Application: SSI 7485

I write regarding the proposed modification to M4-M5 Link, Mod 2 The Crescent overpass and changes to pedestrian infrastructure in North Annandale, Rozelle and Rozelle Bay Foreshore area.

Figure 4-2 Pedestrian and cyclist bridge infrastructure options

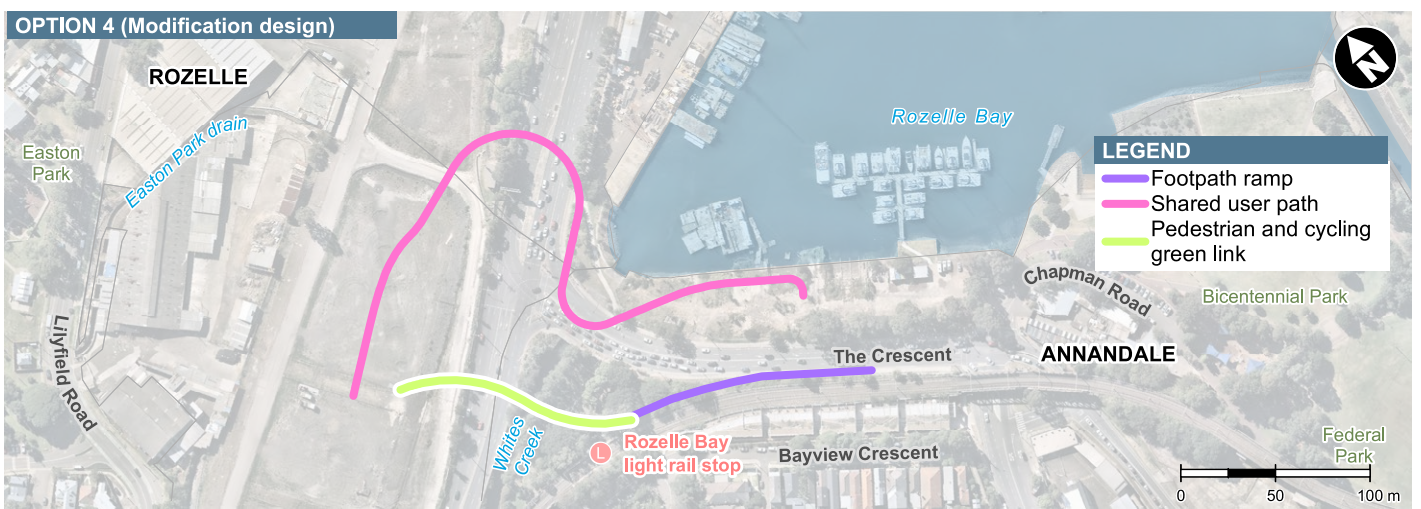
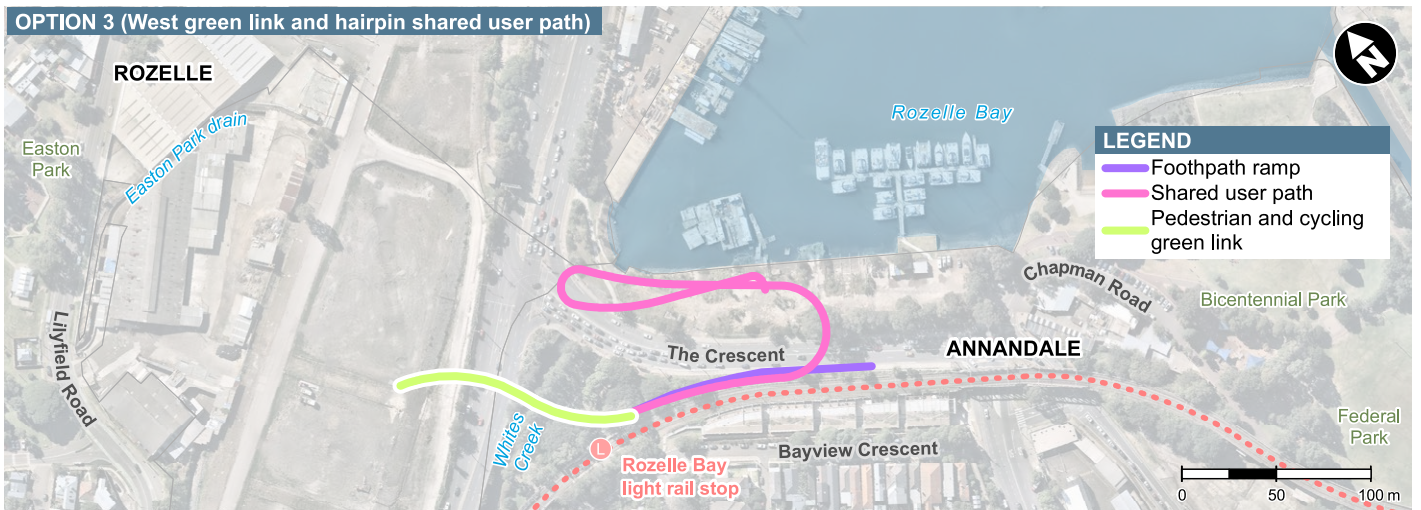
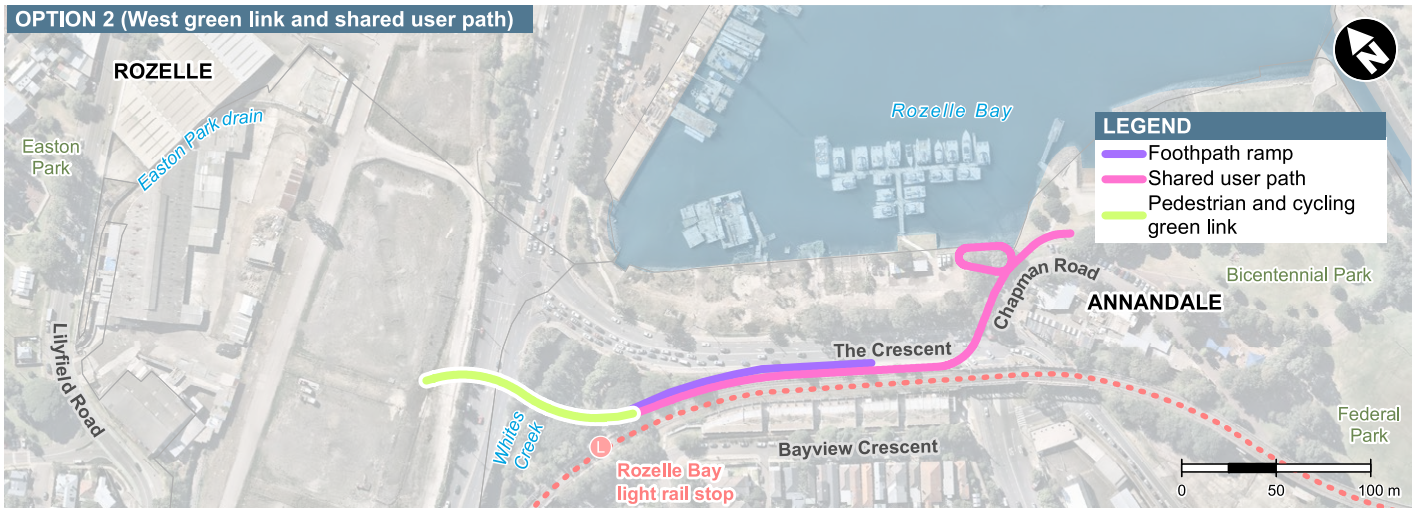
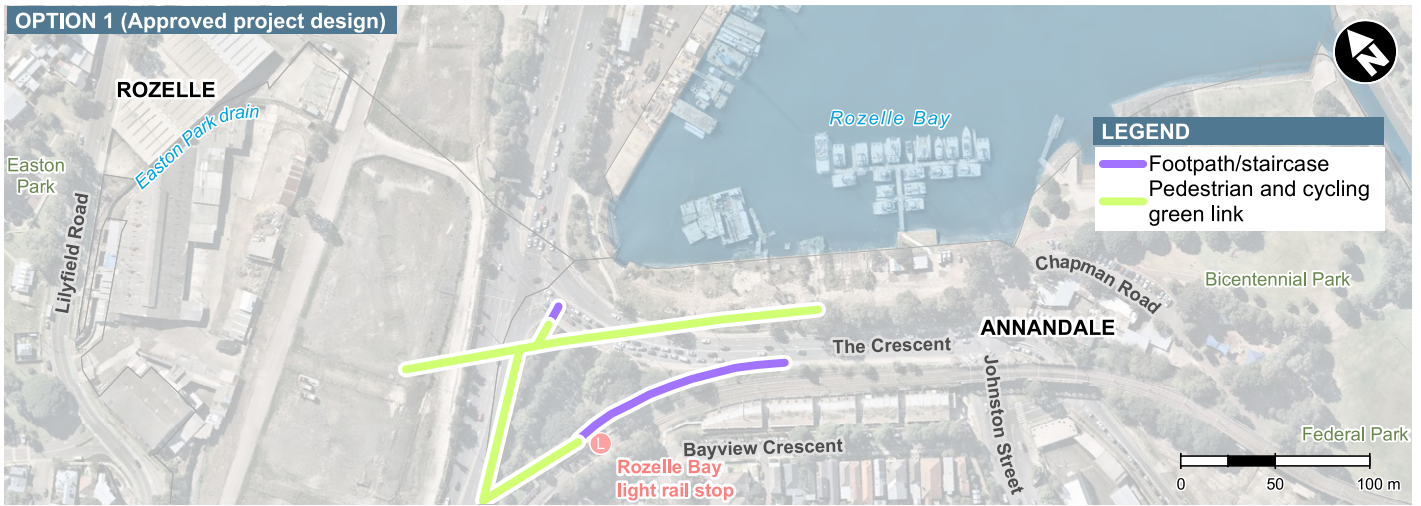
I request RMS work with the community to explore alternate design options to the proposed new car overpass design and the changed pedestrian and cyclist links. I am seeking the reinstatement of the safe, direct access from the approved EIS GreenLink to create a continuous green open space connection from the Rozelle Rail yards and Annandale to the foreshore. The GreenLink was more than just a walk way - it put people central to the design, maximising safety, and providing much needed accessible open space for the community now and into the future Bays Precinct design.

- The significantly reduced safety and increased risk for pedestrians and cyclists with removed access over The Crescent to Bicentennial Park and the increased traffic along Johnson Street.
- Being required to cross five sets of pedestrian lights at The Crescent as my option to reach the foreshore from Annandale or from Rozelle Bay light rail stop.
- Removal of direct active links to the foreshore, cutting the community off from the area and the proposed revitalisation of the entire Bays Precinct, including linking the Light Rail and Bus stops to a Ferry wharf and Metro station.
- Urban and landscape design that is being built before a finalised Masterplan for the area.
- Traffic changes that limit movements around the suburb and create further congestion in the local streets of Annandale, Forest Lodge, Glebe, Lilyfield and Rozelle with no planning to deal with these.

- Reinstate the GreenLink connecting communities and green open space from Rozelle to Bicentennial Park.
- Relocate and design pedestrian and cyclist connections that are continuous, safe and direct.
- Design the modification infrastructure and active links in response to the character of the suburbs, the location of the foreshore and it's potential future development.
- Provide pedestrian and cyclist paths that maximise people's safety and do not force us onto busier streets, unsafe concrete plazas and caged walkways.
- Integrate active and direct connections to all active transport – including the future Metro West and Foreshore Ferry Wharf.

Figure 4-3 The Crescent, Johnston Street, Chapman Road intersection options

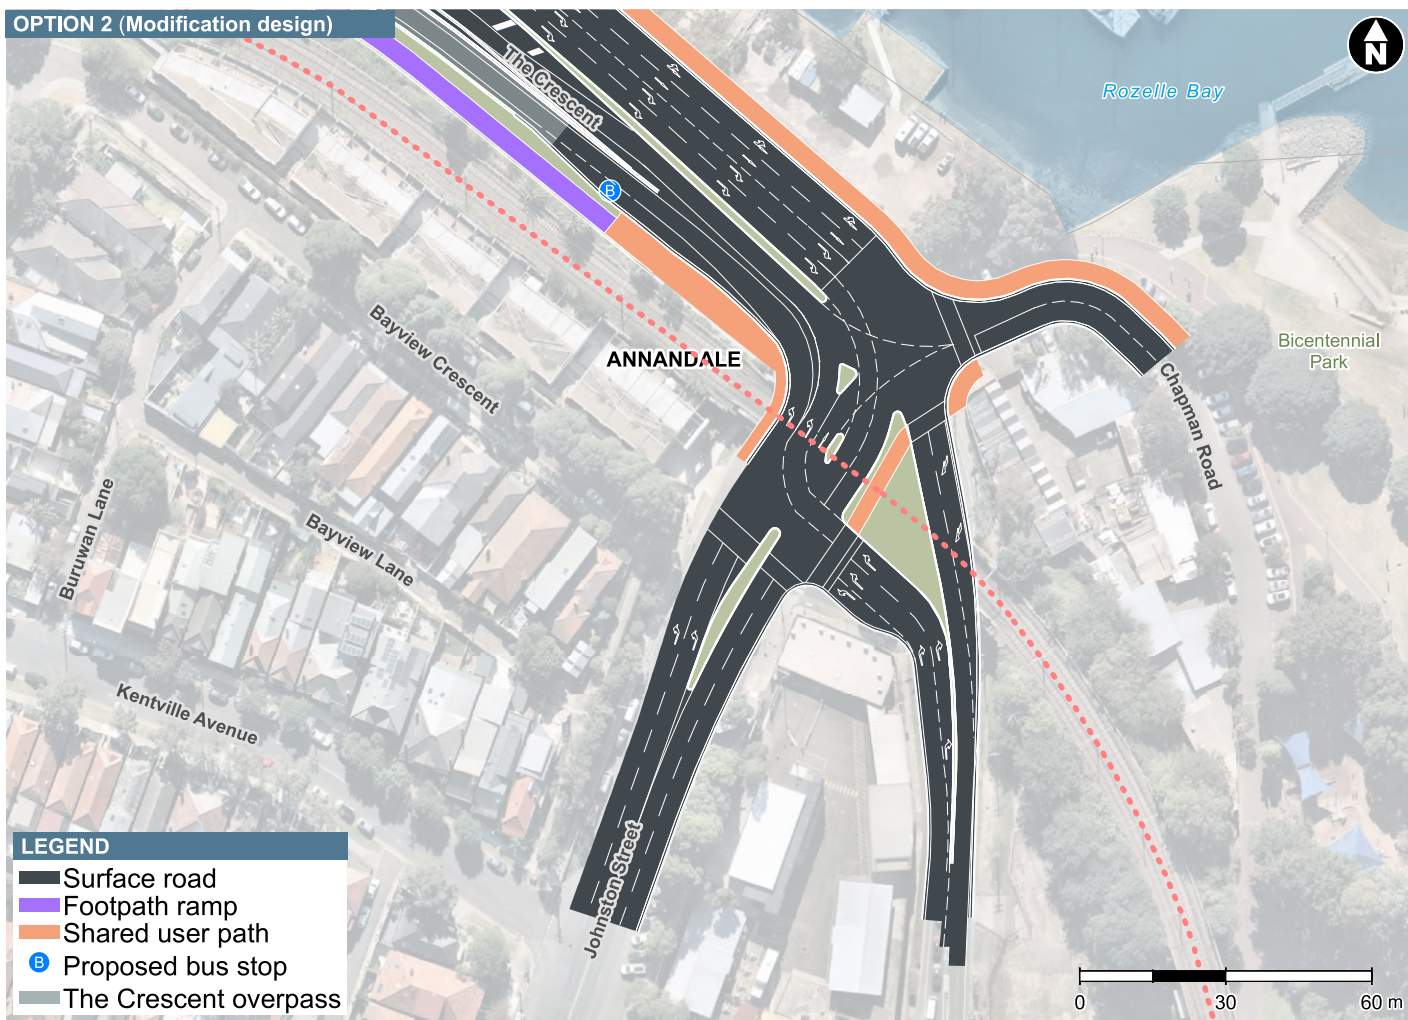
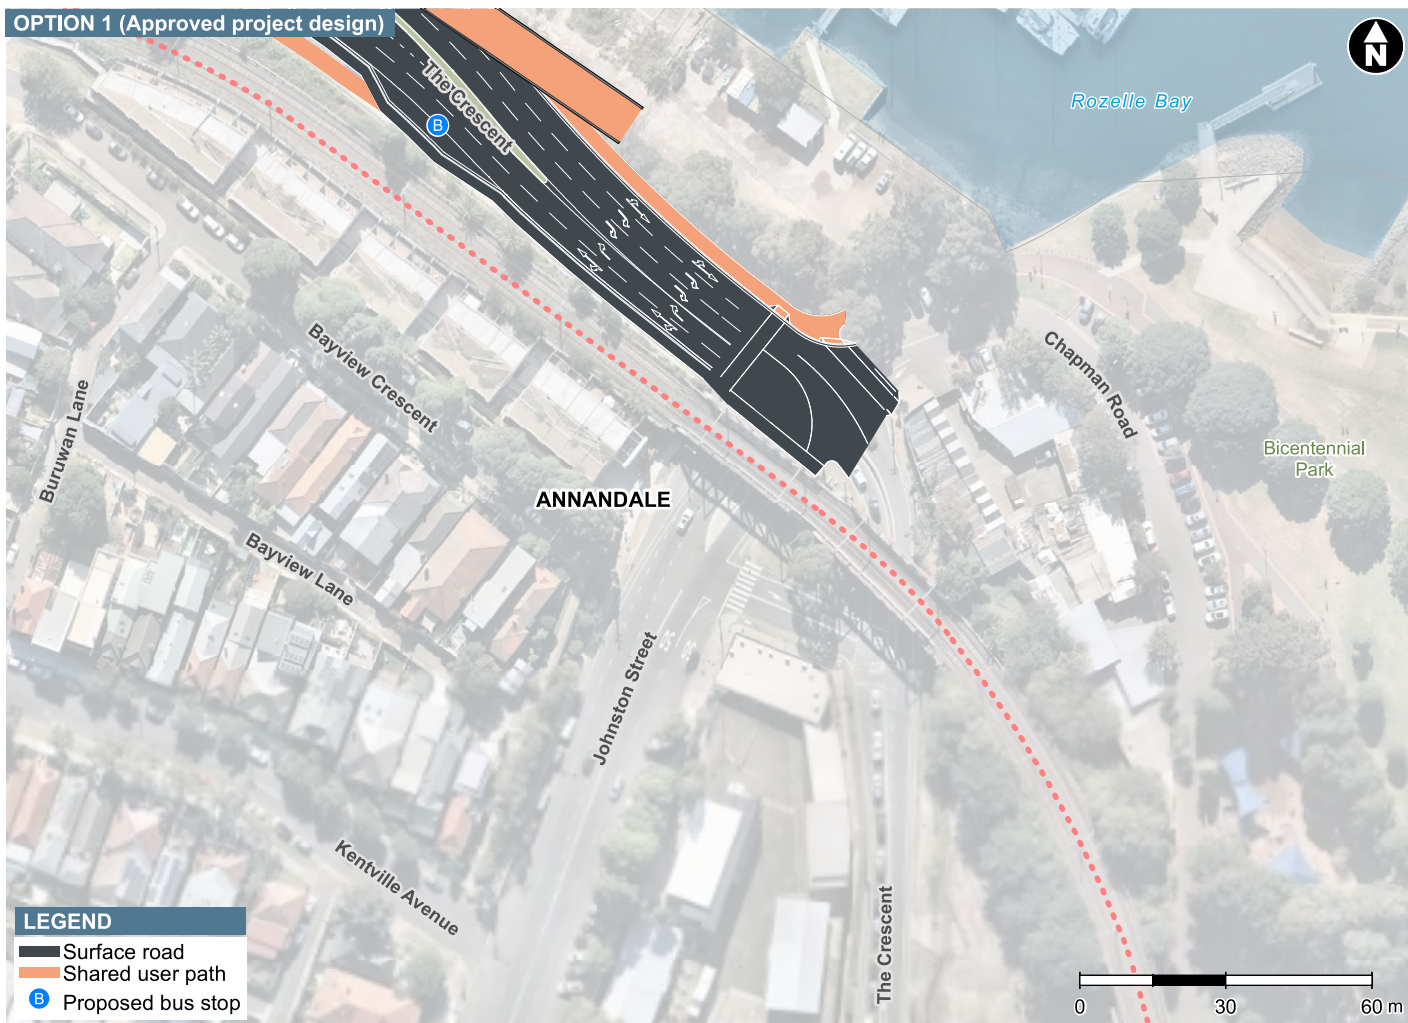
I would also like to point out that the Glebe park (Jubilee Park) w/ the offleash area is frequented by a lot of locals – w/ pets + children + having access from Johnston street to the park ~~where~~ both pedestrian, cyclist + car access is extremely important for the community + safety of everyone.
